HyNet North West

Annex D

CORRESPONDENCES Rev B

**21/02454/AAC Request for a formal opinion on the scope of an
Environmental Statement (ES) under Regulation 10 and 11 of the
Environmental Impact Assessment Regulations 2017: HyNet North West
Carbon Dioxide Pipeline**

**Pentre Halkyn - Block Valve Station (BVS) Drainage Layout**

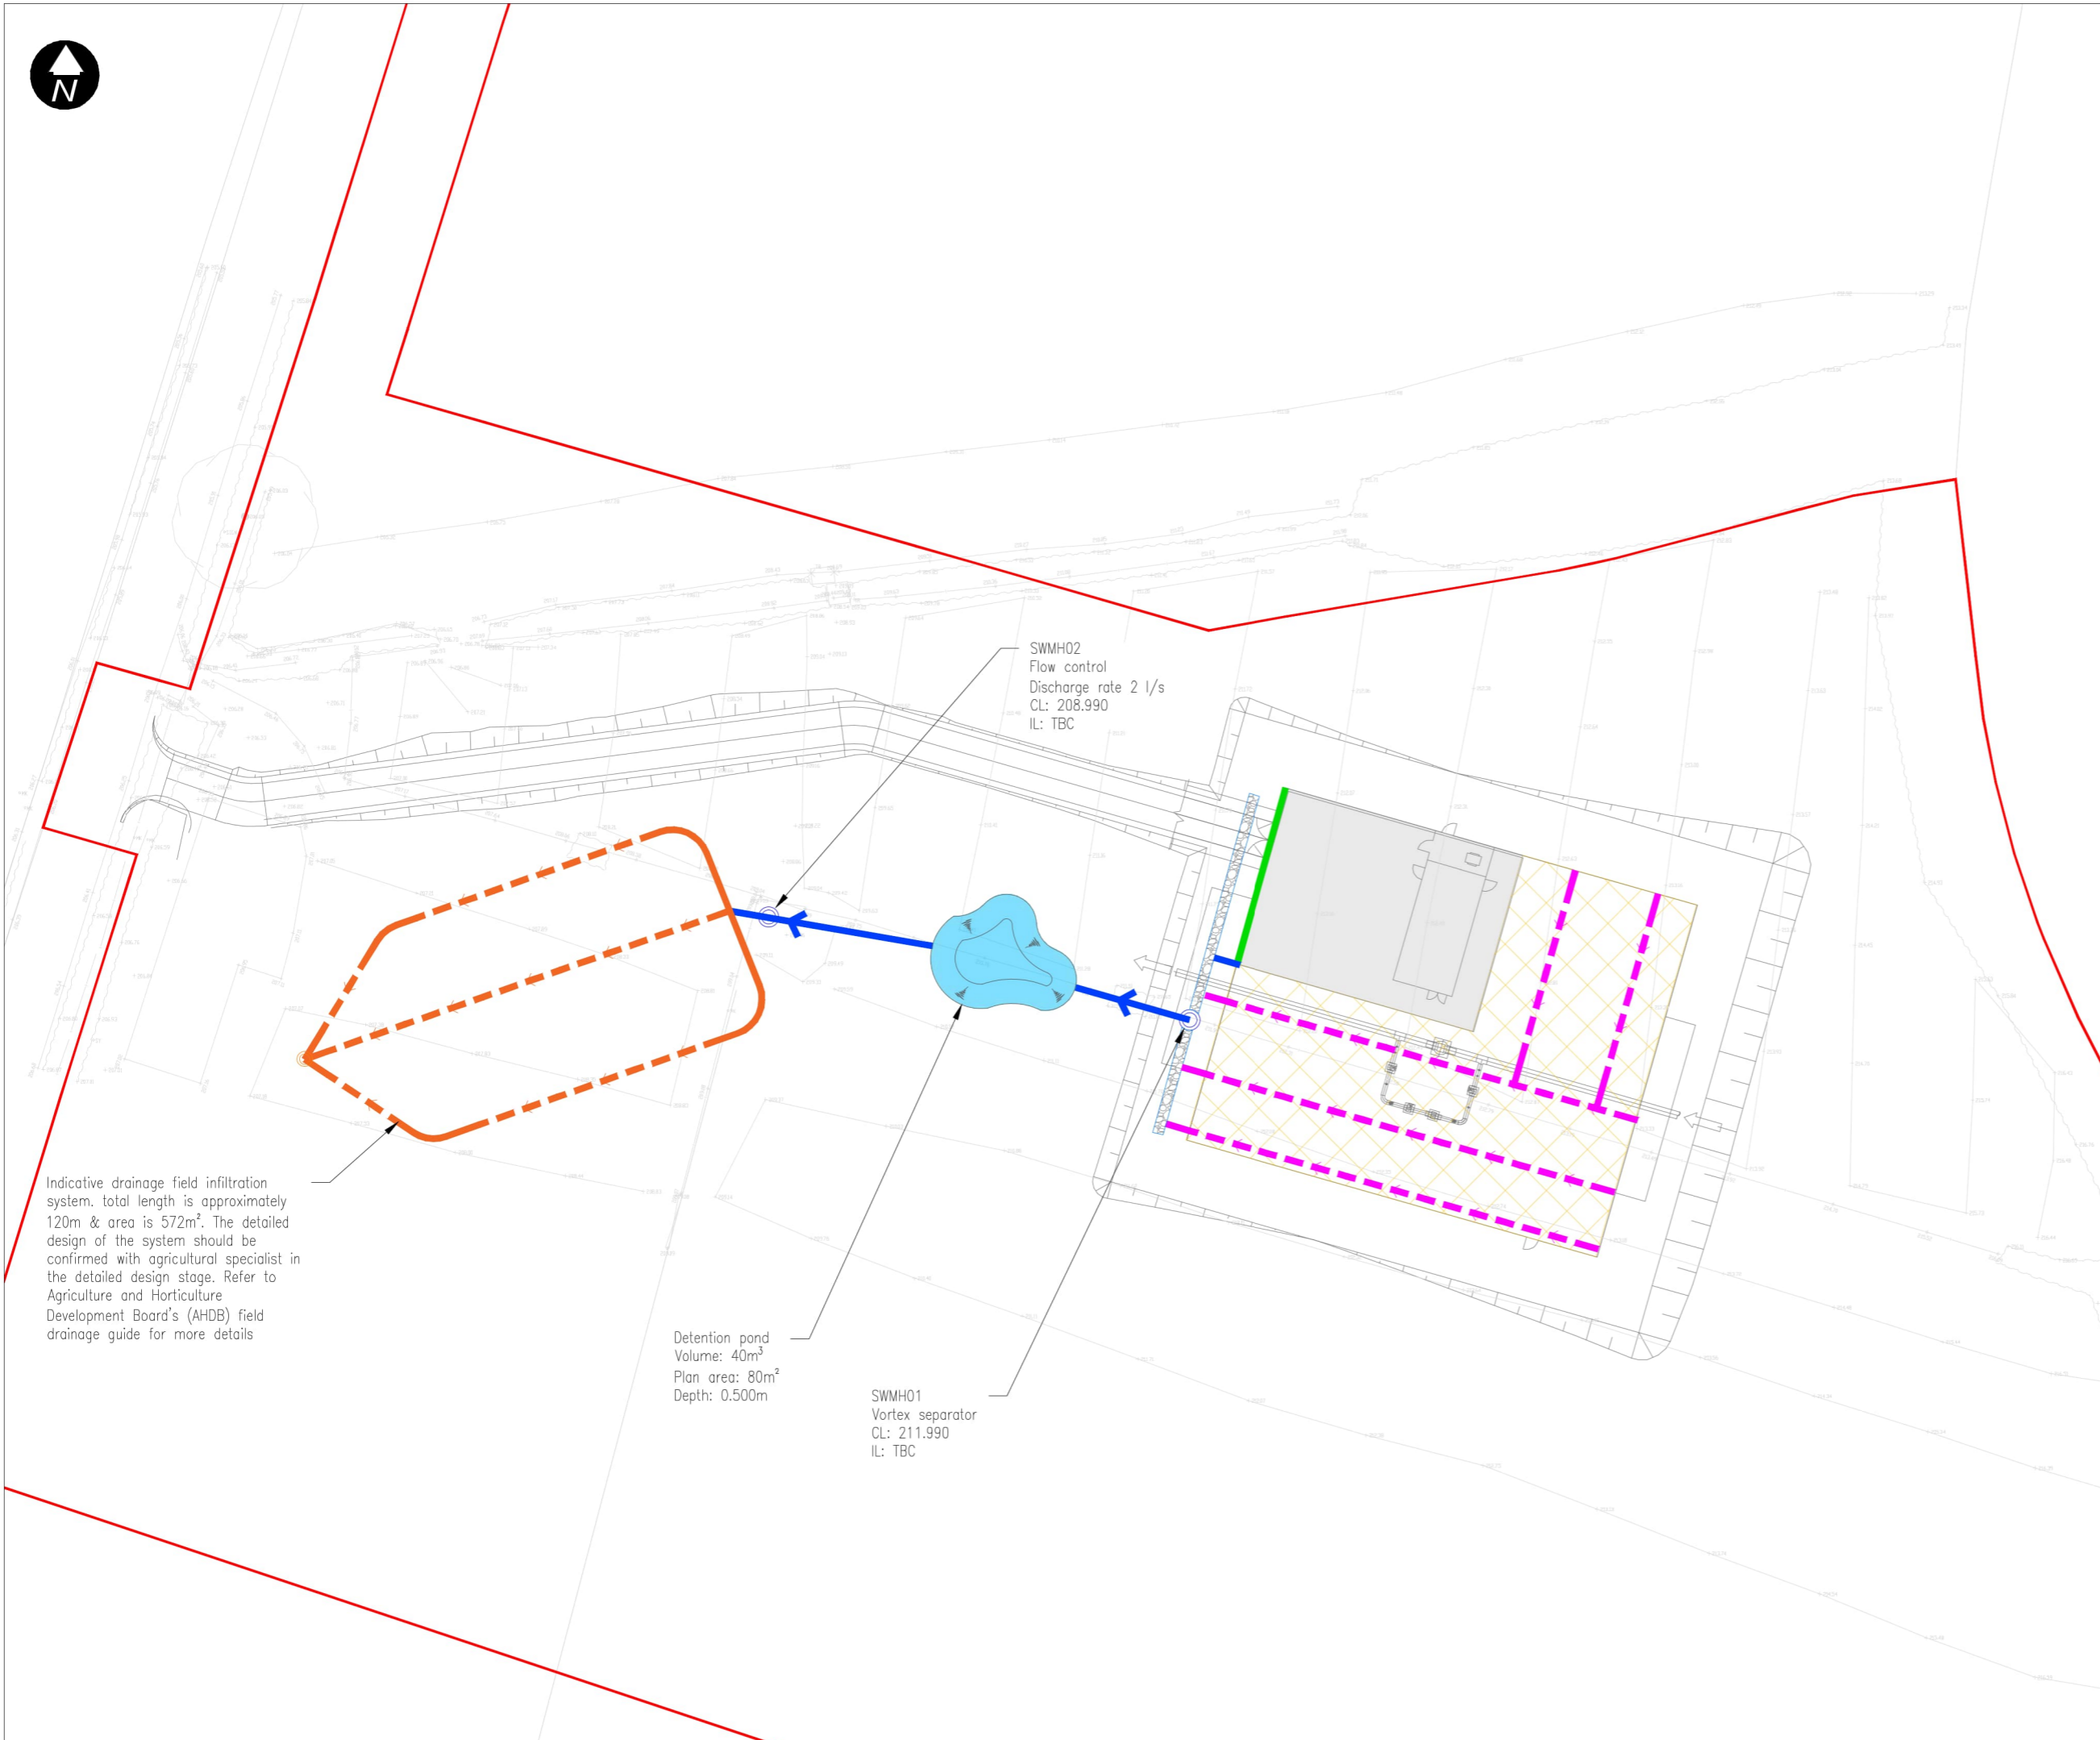
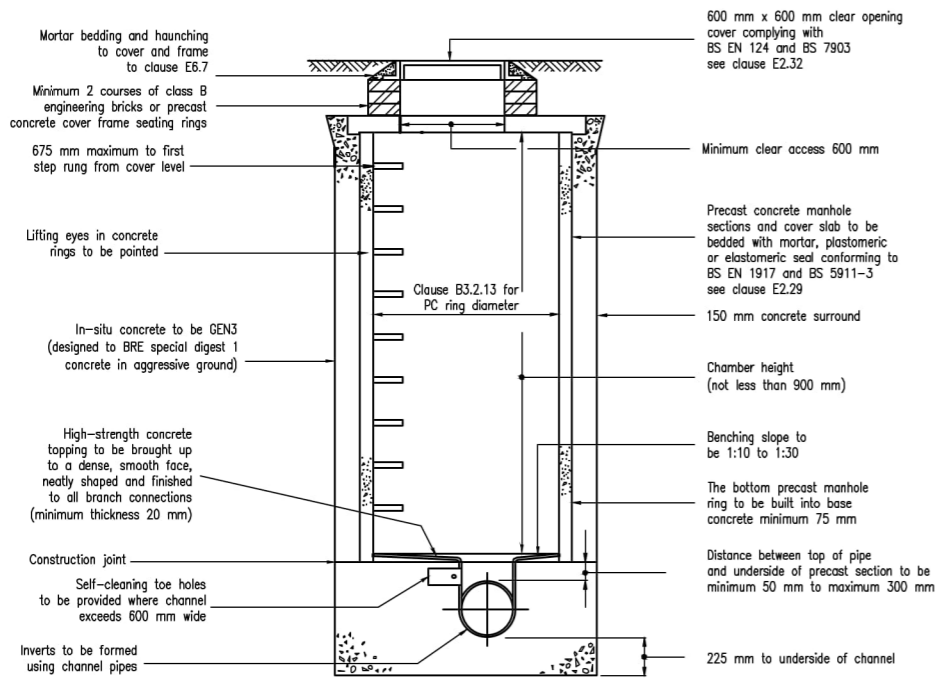
- 3) *Pentre-Halkyn and Babell – use of slow infiltration system using a drainage field system spread over a larger area*

- For two sites (Pentre-Halkyn and Babel) we had to take a different approach to surface water drainage.
- In line with the Drainage Hierarchy below:

As all options are exhausted under the Drainage Hierarchy we decided to revisit Priority Level 2 and produce a slow infiltration system using a drainage field system spread over a larger area. Does the consultant agree with this approach?

It appears that all drainage options have been exhausted and as such we would be happy for an infiltration based system to be used. The use of permeable surfaces is encouraged as to create a large storage and infiltrating surface area.
